# CITY OF PORTLAND BUILDING PERMIT

**PERMIT ID:** 2013-00179

has permission to **Renovation of the kitchen and dinning room of Hugo's Restaurant**  
provided that the person or persons, firm or corporation accepting this permit shall comply with all of the provisions of the Statues of Maine and of the Ordinances of the City of Portland regulating the construction, maintenance and use of the buildings and structures, and of the application on file in the department.

**Jeanie Bourke - Re: Hugo's permit review**

**CODE ANALYSIS PLAN**

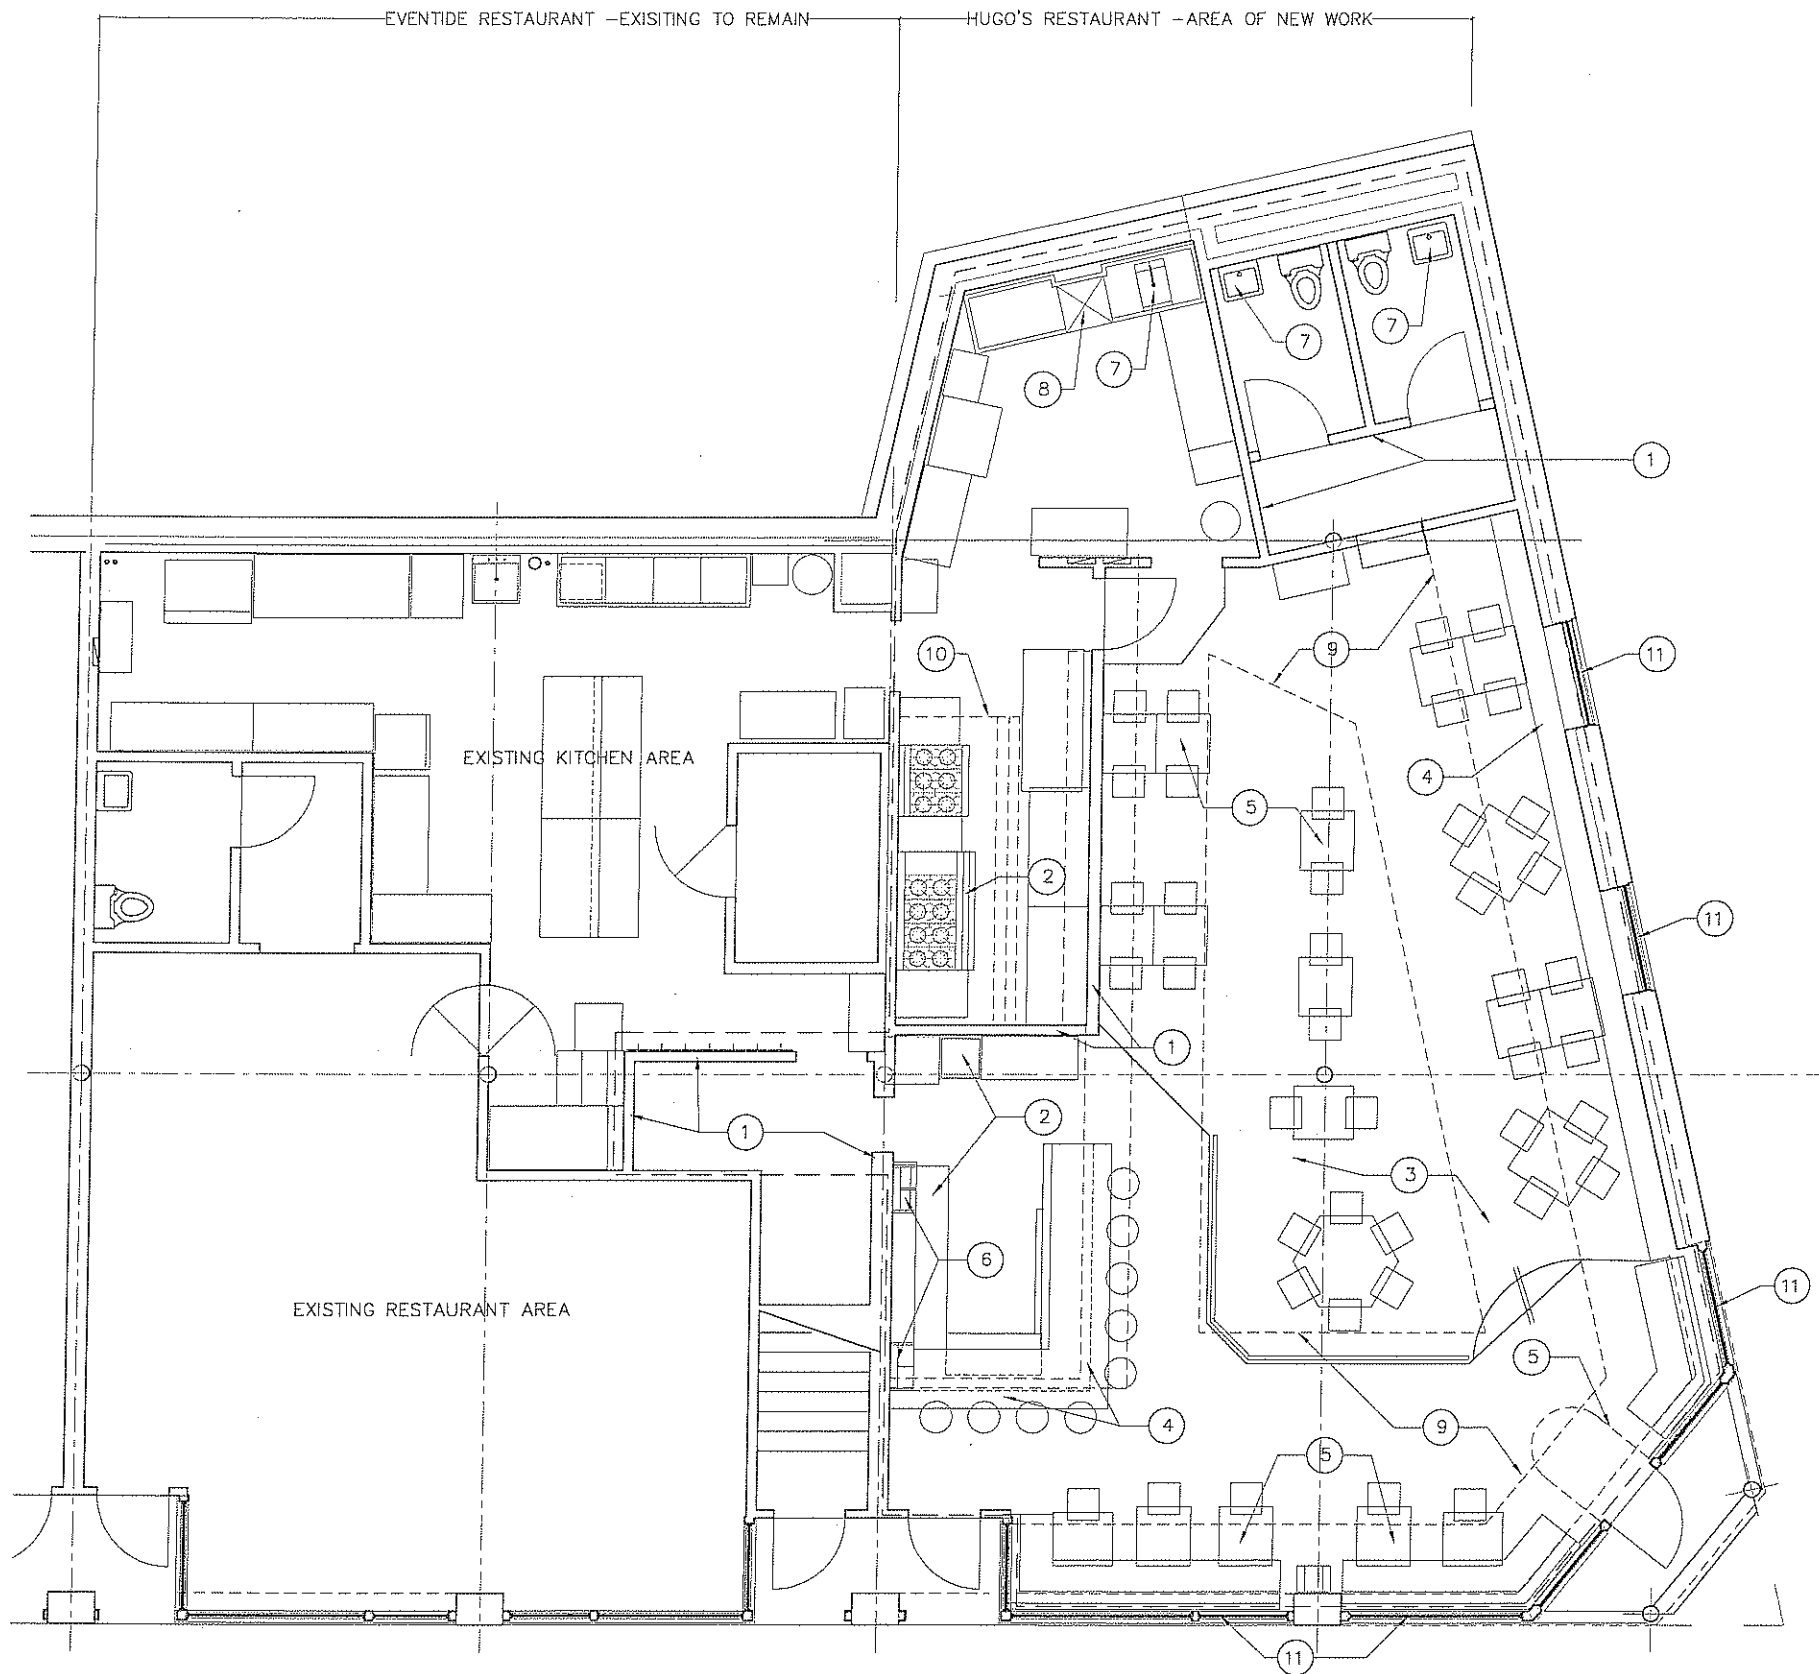
A question for you, the building type classification is 2A, which would require noncombustible construction. The new interior partition wall type calls for wood studs. Do you want to change this or determine if the building could be classified as type 3A?

As we have recently discussed, please be advised that I would like to amend our Building Permit application (for Hugo's Restaurant @ 88 Middle Street) to reflect a Type III b Construction Classification (from Type II a) in order to be consistent with previous permit applications for the building.
